***Waynflete Arts Center***  
***Phase Two***  
***July 3, 2007***

**MEMORANDUM Site Plan Punchlist Memorandum**

**date:** July 3, 2007  
**project:** WAYNFLETE ARTS CENTER, PHASE TWO, 2003-0040  
**re:** Major Development, Site Plan Punchlist questions of May 31, 2007  
**to:** Shukria Wiar  
Planning Department City of Portland  
**from:** Austin Smith Scott Simons Architects (SSA)  
**cc:** Scott Simons SSA  
Charles Young SSA  
Anne Hagstrom Waynflete  
David Cimino Stroudwater

WAYNFLETE ARTS CENTER
360 SPRING STREET, PORTLAND, MAINE
Mechanical Screening at RTU

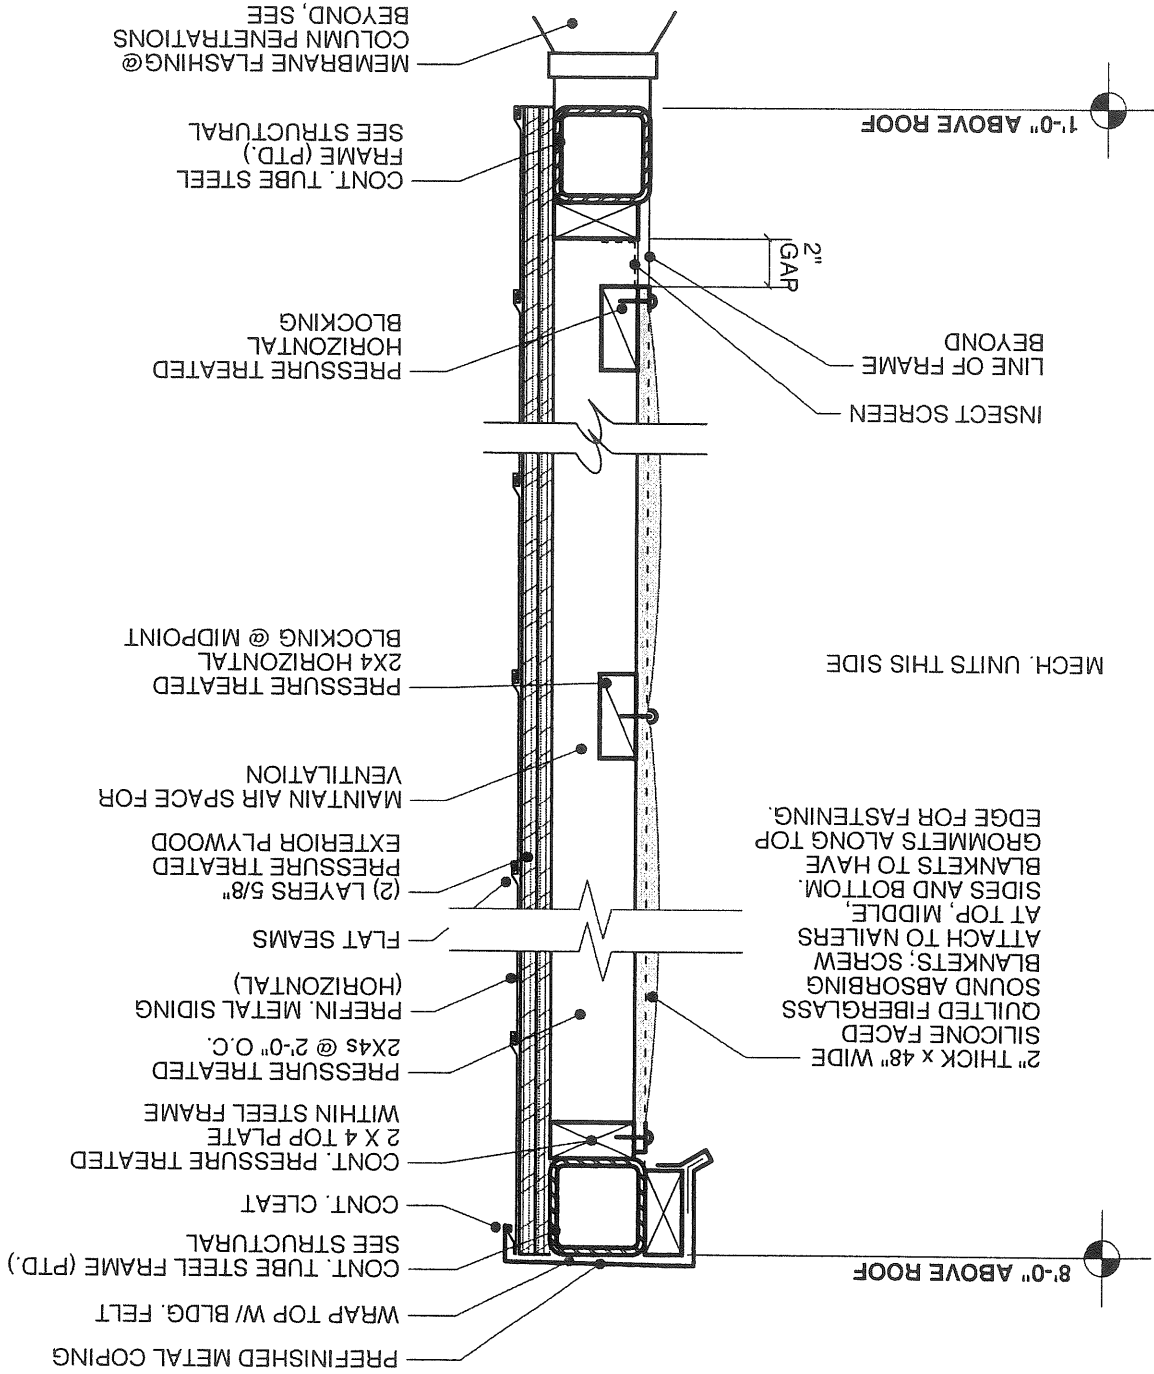
16. *The project proposes a new roof top mechanical unit, submit evidence of the measurement to be taken to lower the noise level.*

The roof top mechanical unit was previously shown centered on roof of the future gymnasium; running east/west. This will be repositioned to run north/south and moved to the far east side of the roof to lessen its visual impact. Unit will be ducted from the bottom lowering the overall height of the unit by 4 feet. The revised position is reflected on the enclosed revised drawing A-1.3, dated July 2, 2007. In addition to the repositioning of the unit, acoustic mechanical screening will be incorporated. Detail SK-3 shows the construction and configuration of the visual and acoustic barrier.

Figure G
Typical curb along Storer Street

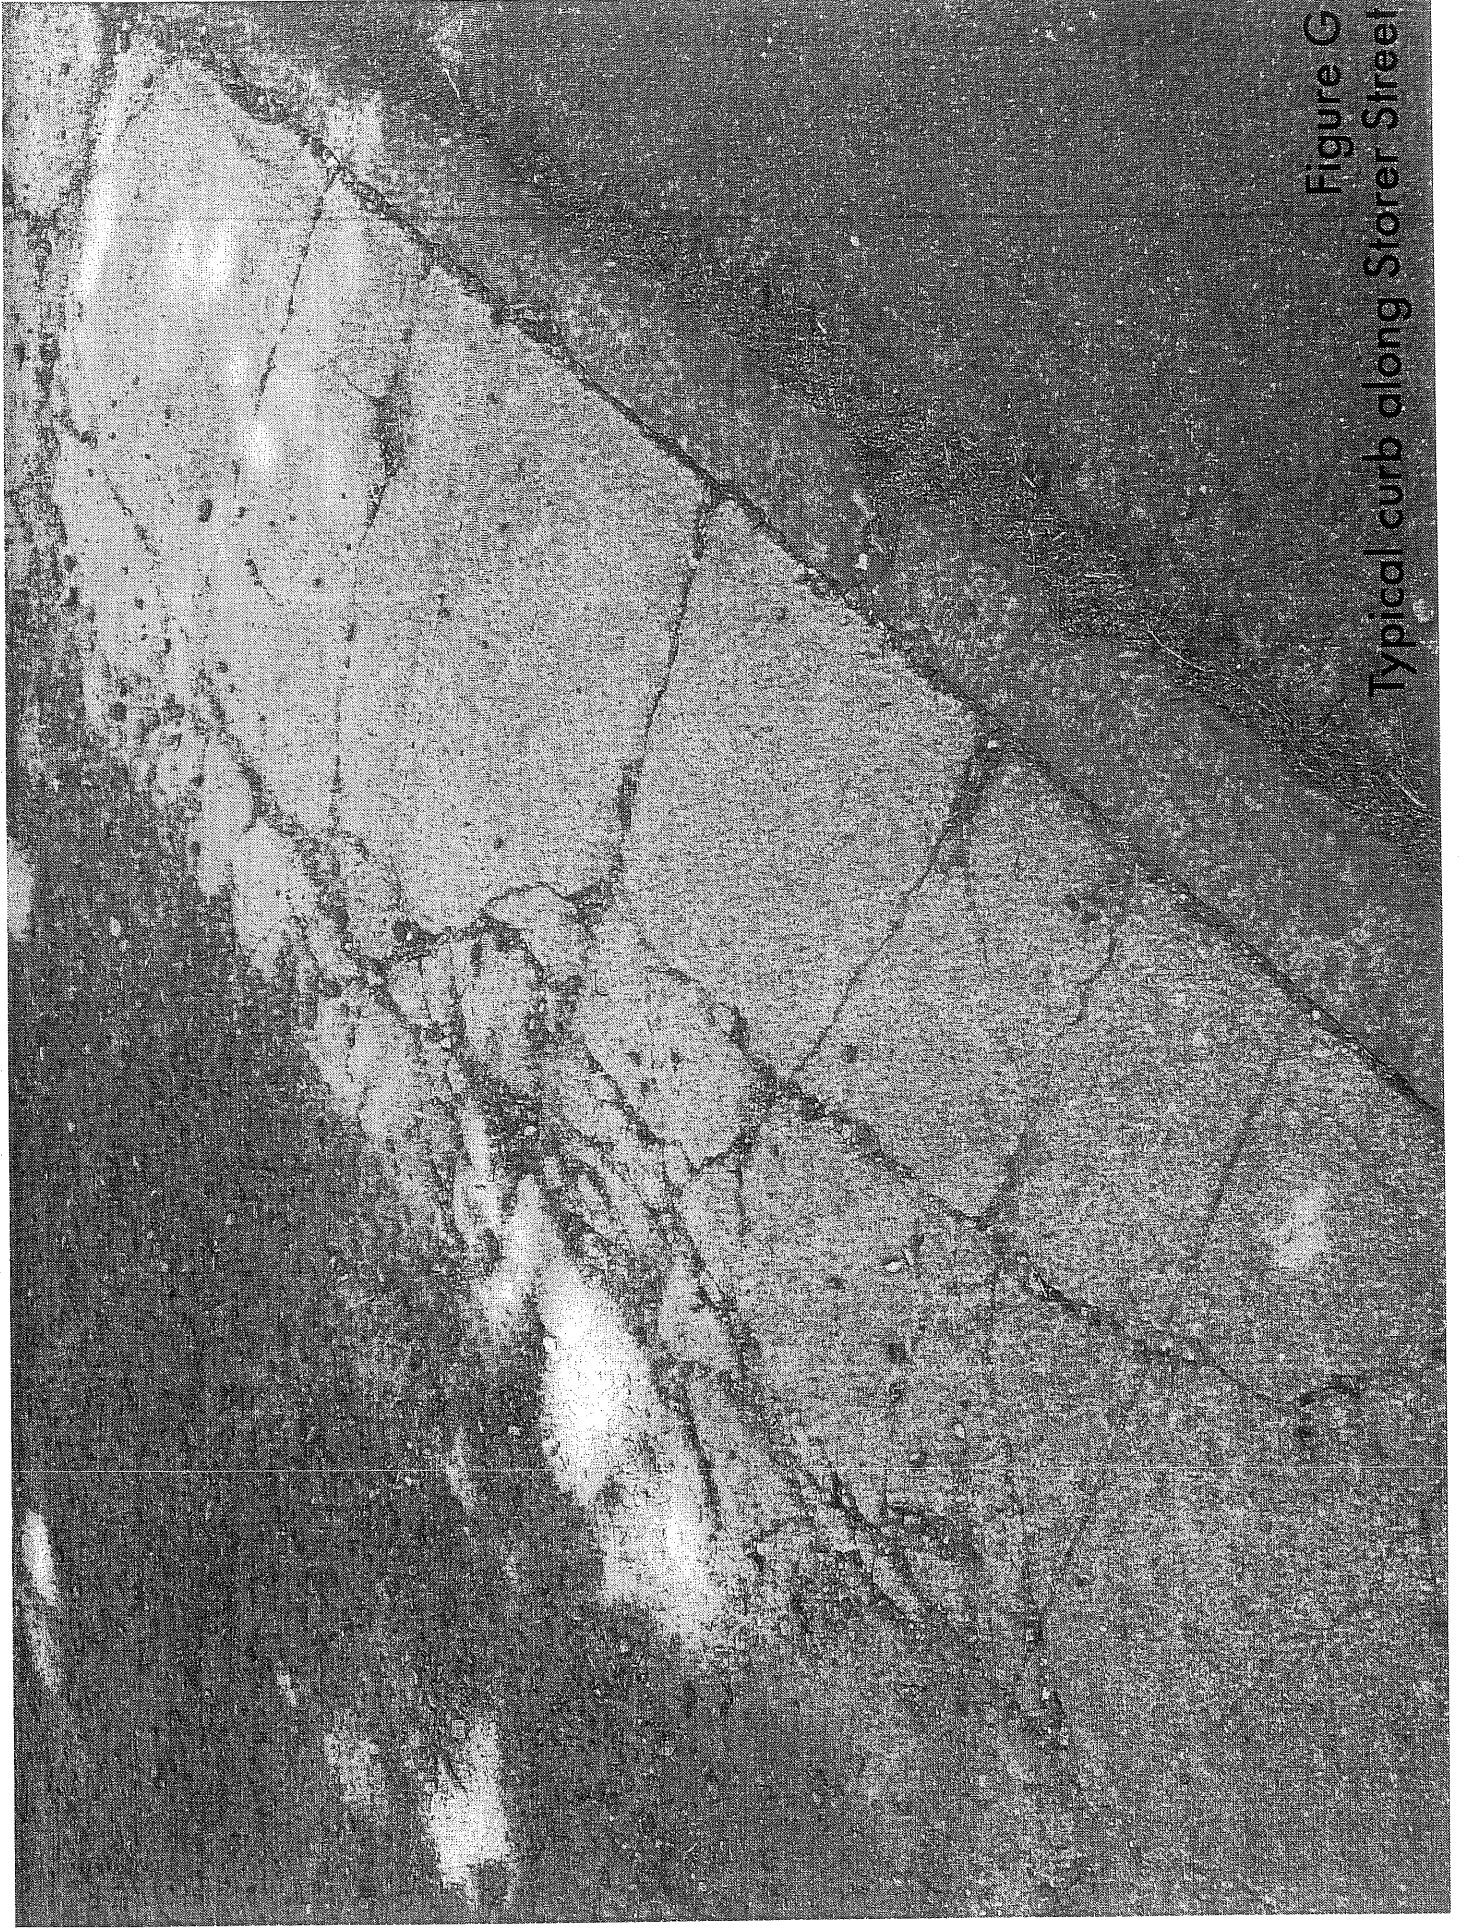
- d. *New Handicapped ramps should be constructed at the corner of Storer and Danforth Streets. The associated details will need to be included.*

- e. *The conditions of the existing sidewalk should be indicated.*

Concerning both items d. and e. please note the condition of Storer Street edge, curb and sidewalk in the enclosed photographs. In 2003 a new paving overlay was installed on Storer between Spring and Danforth Street. This raised the top of paving to within 1" to 1 1/2" of top of curb. Without addressing the pavement elevation, it is difficult to reset curb heights for long term ADA compliance.

Existing sidewalk of the west side of Storer Street is cast in place concrete with granite curbing. See enclosed photographs of existing site conditions including Storer Street curbing / sidewalk , existing Norway Maple tree and Danforth Street sidewalk, stone retaining wall, plantings, and fencing.
